**COMMUNITY SERVICES DEPARTMENT**

October 13, 2022

**Subject: Meadowlake Airport Expansion 1041 Permit Application (AASI-22-002)**

The Park Operations Division of the Community Services Department has reviewed the Meadowlake Airport Expansion 1041 Permit application and has the following comments on behalf of El Paso County Parks.

AIRPORT LAYOUT PLAN - FUTURE		
CDAG GRANT NO. 2014-FLY-01	JVIATION PROJ. NO. 2014.FLY.01	DATE: MAY 2019

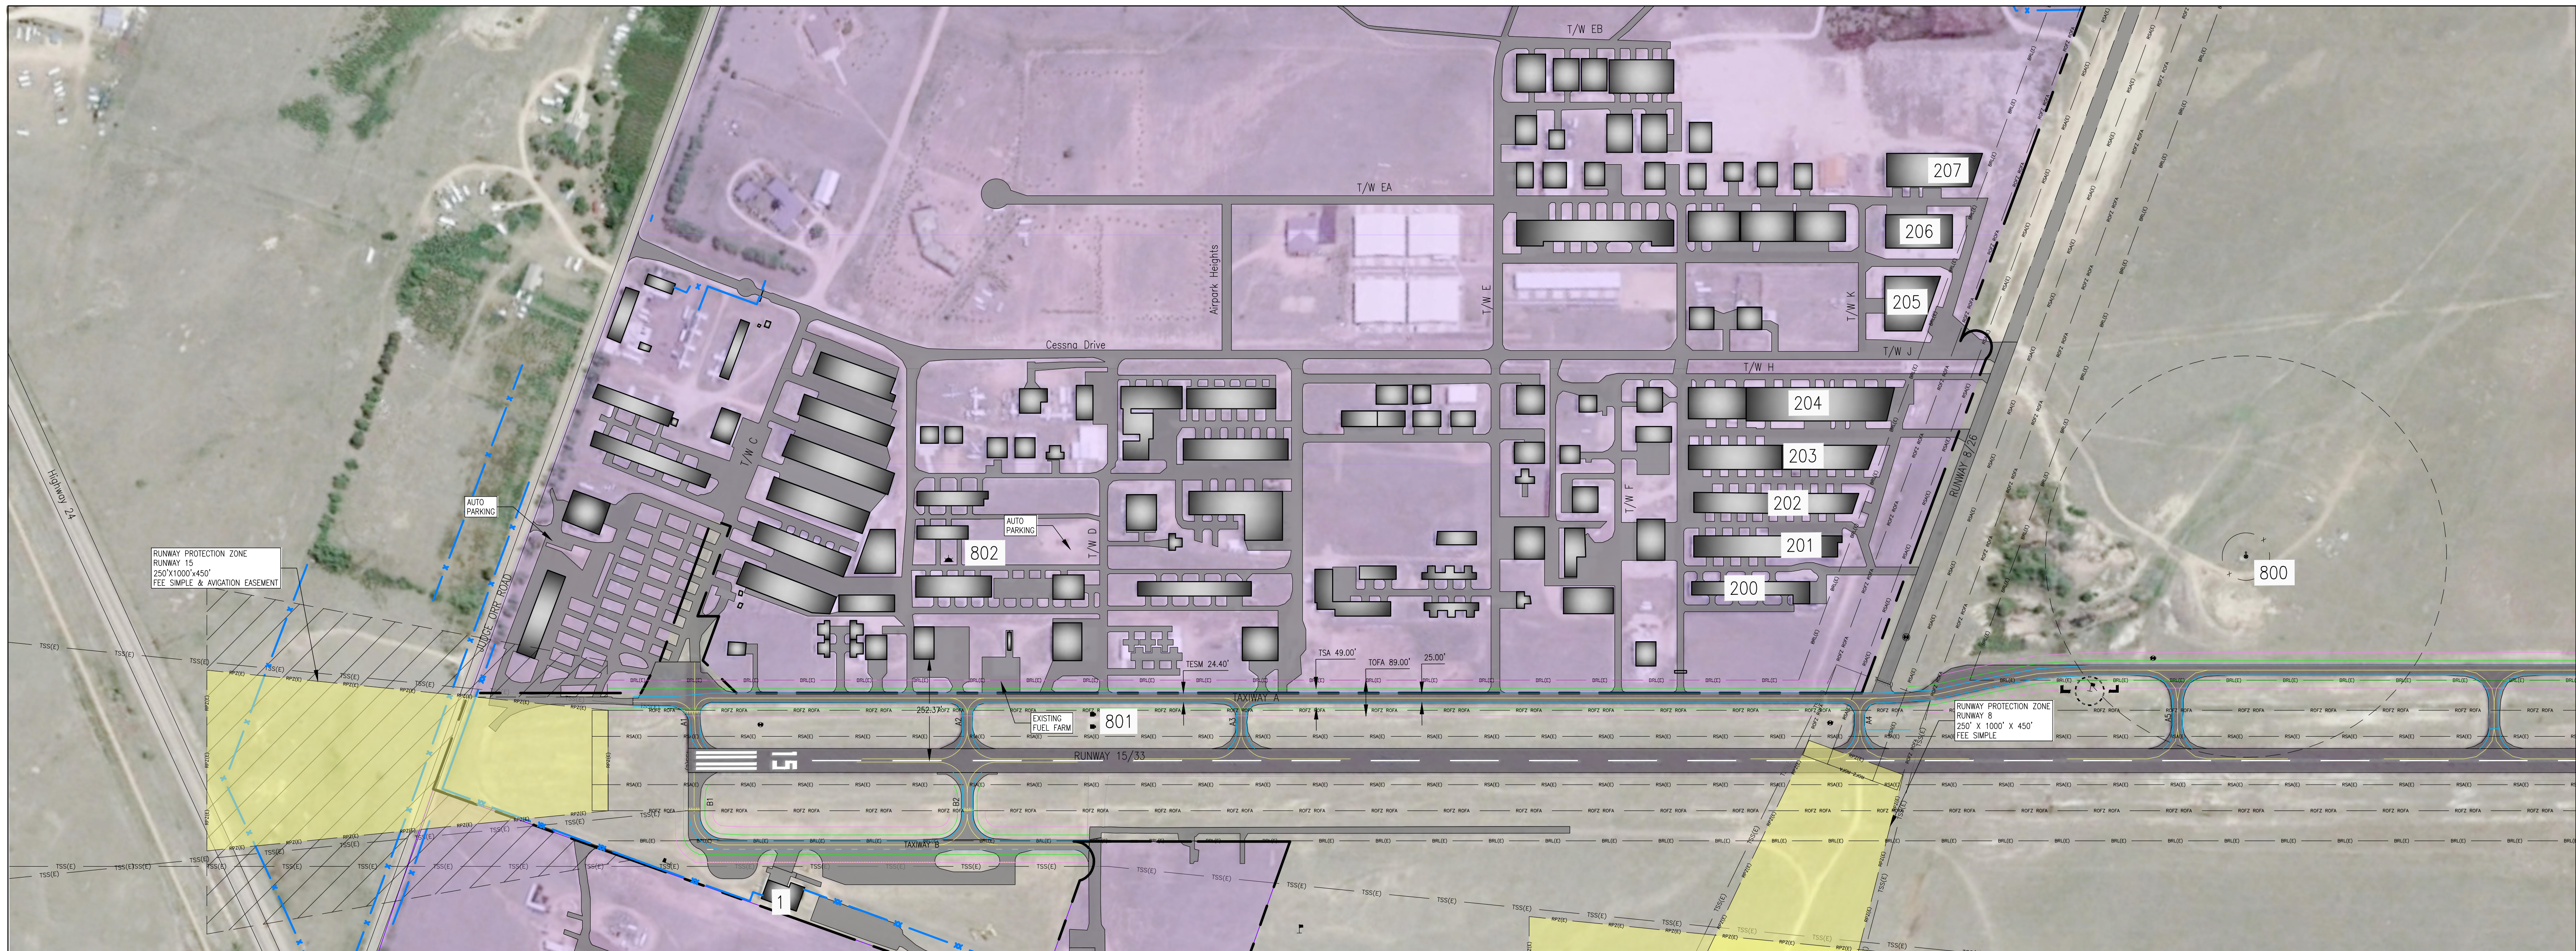
Sheets 4 and 6 – Airport Layout and Terminal Plans, Future – of the submitted Airport Layout Plan Drawing Set shows a secondary entrance to Meadowlake Airport to access the proposed hangers, fuel station, terminals, and associated airport buildings located west of the main runway. This proposed airport entrance would require drivers to use Mallard Drive and Sissy Way to access the airport, thus introducing a higher amount of traffic on roads that normally serve a rural residential neighborhood.

As previously noted, El Paso County Parks' Drake Lake Natural Area and its roadside parking area are located immediately west of the intersection of Mallard Drive and Sissy Way. Should the 1041 permit application process determine that these two roads would be detrimentally impacted by heavier traffic loads and therefore benefit from asphalt paving, Drake Lake Natural Area and its small parking area could be greatly impacted by increased stormwater runoff from the road's impervious surfacing. As such, EPC Parks requests that the possible paving of Mallard Drive and Sissy Way extend into and include the Drake Lake parking area, and stormwater drainage improvements be designed and constructed to eliminate stormwater runoff impacts to the sensitive Natural Area, including the wetlands located between the parking area and lake. This could be accomplished through roadside ditching or curbing to direct waterflow to an appropriate outlet point along Mallard Drive.
